**re: Grading and Site Servicing Plan Review**  
**Proposed Self Storage Development**  
**75 Michael Cowpland Drive – Ottawa, Ontario**

**date:** November 24, 2023

**file:** PG3798-MEMO.02 Revision 3

PROJECT MGR:
R.M.

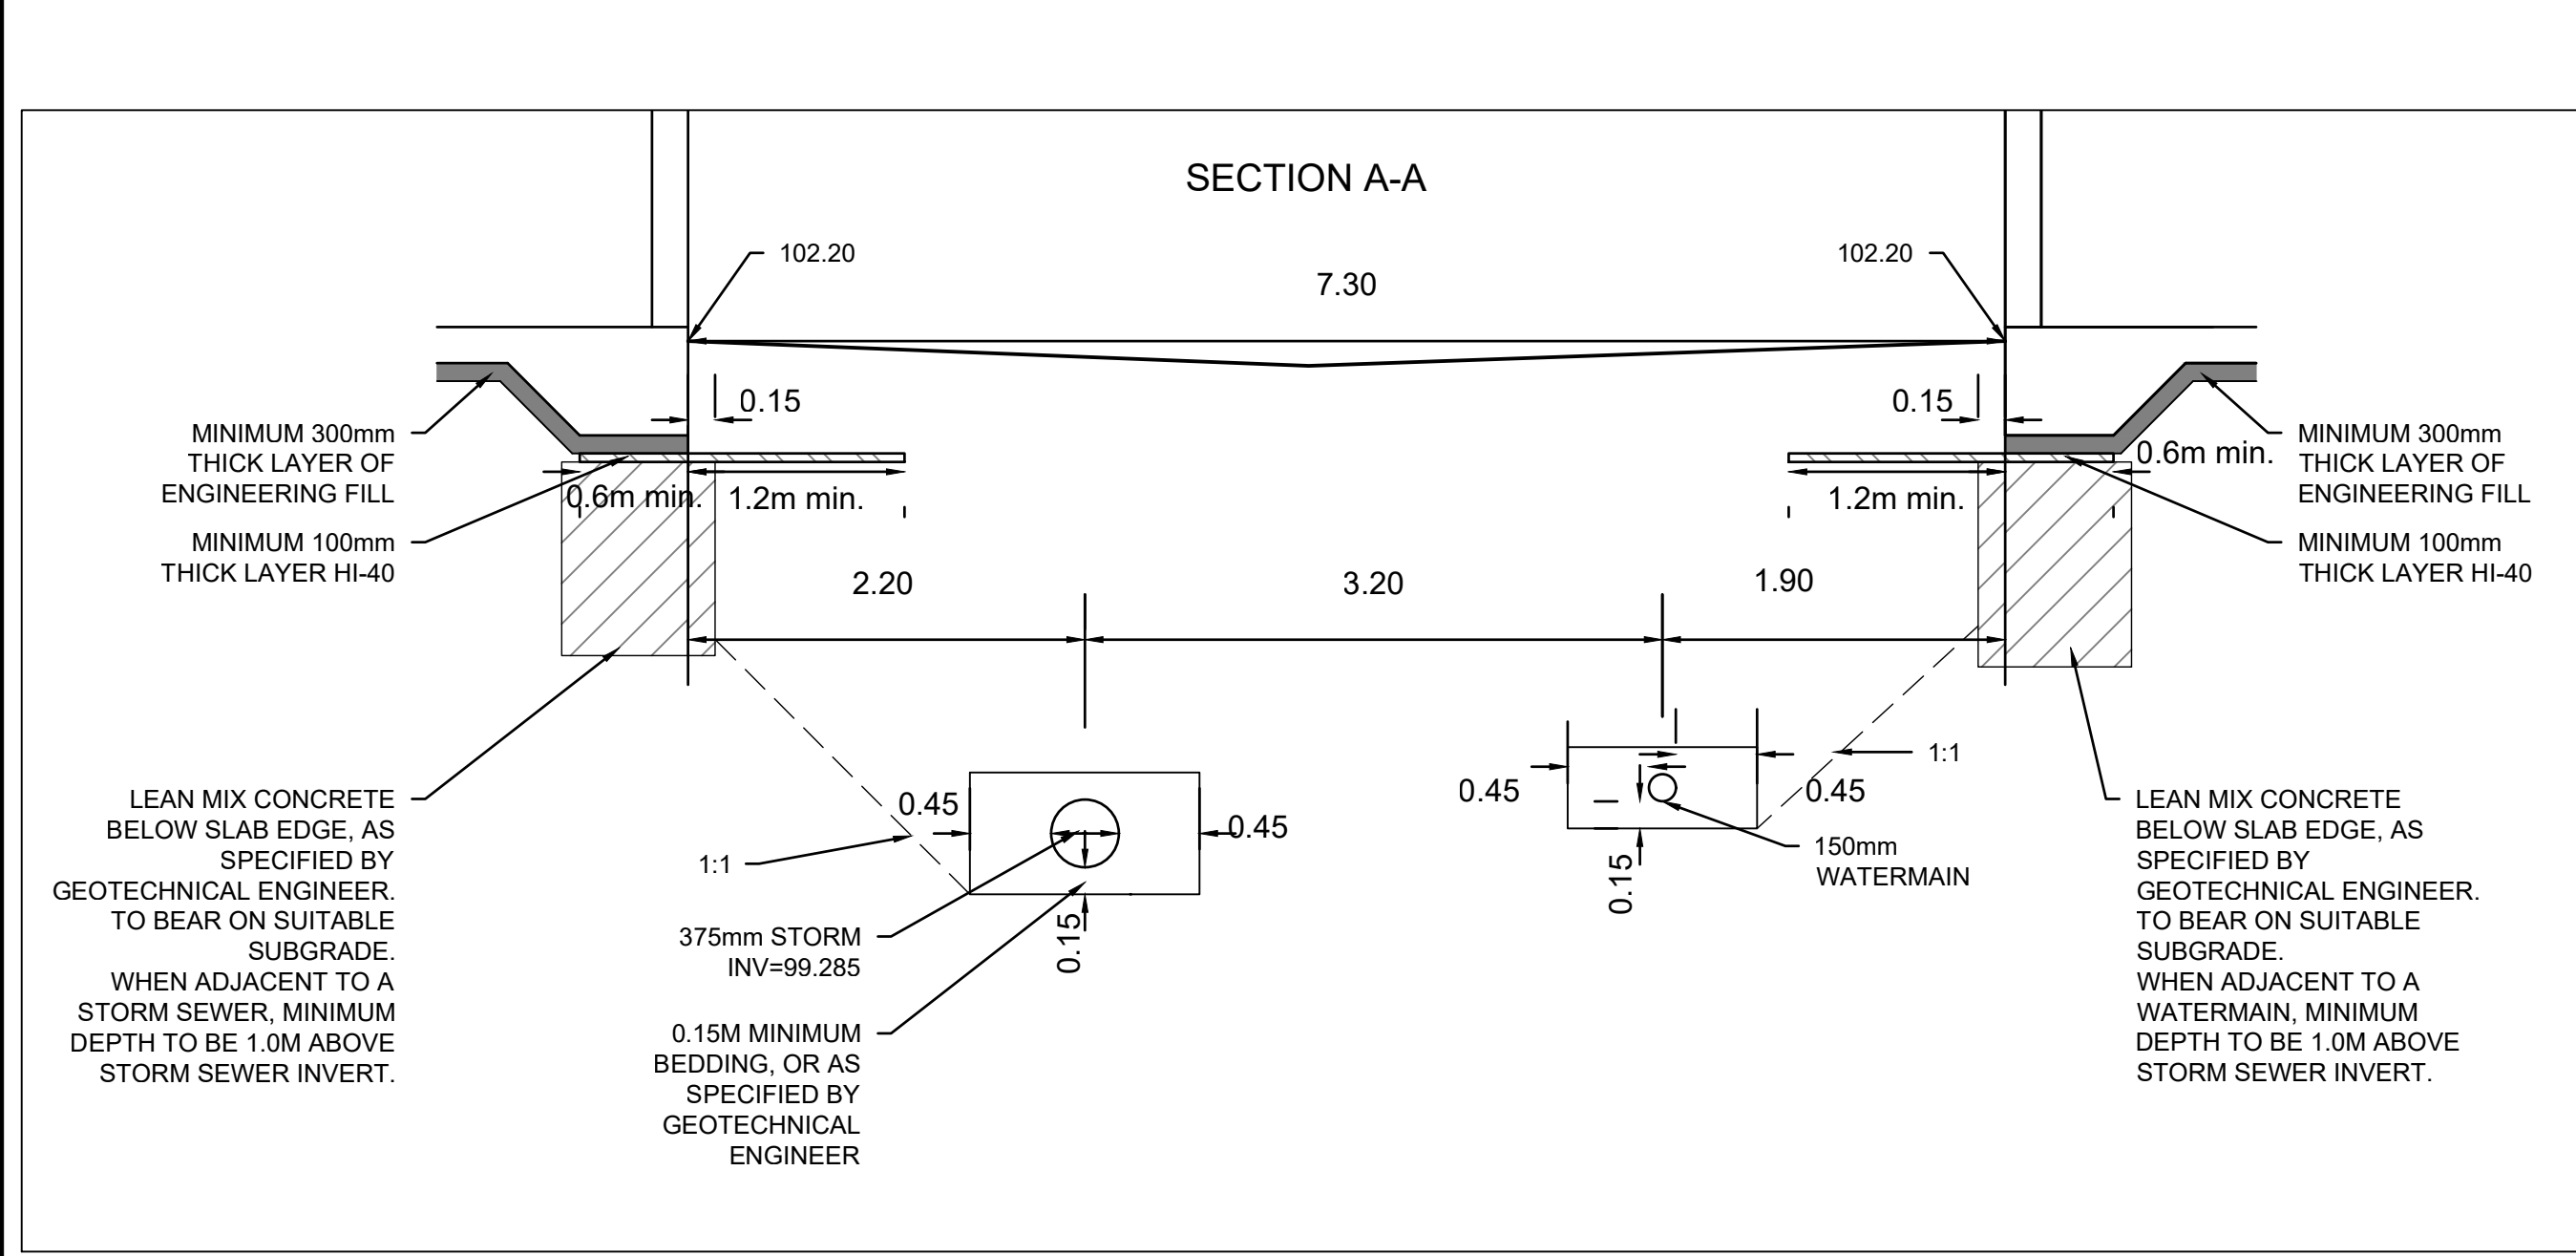
Due to the anticipated depth and proximity of the proposed service pipes to the proposed thickened edge slab footprints, it is expected the lateral support zones for the proposed structures will be negatively impacted by the service installation works. Further, future maintenance that could be considered throughout the proposed service alignments would require trenches that would impact the proposed buildings lateral support zones. Based on this, it is recommended to lower the lateral support zones for thickened edge footings located adjacent to impacting service alignments. This may be accomplished by sub-excavating a near-vertical trench located directly below the overlying footing footprint and in-filled with minimum 17 MPa lean-concrete.

It is recommended the near-vertical trenches extend a minimum of 150 mm horizontally beyond the overlying footing footprint. Based on our review, the lean-concrete trench detail has been incorporated satisfactorily into the above-noted site servicing plans. The recommended perimeter thickened-edge slab foundation insulation detail is depicted below for the proposed storage structures and has been incorporated satisfactorily in the above-noted site servicing plans. The placement of the lean-concrete trench and rigid insulation should be reviewed and approved by Paterson personnel at the time of construction.
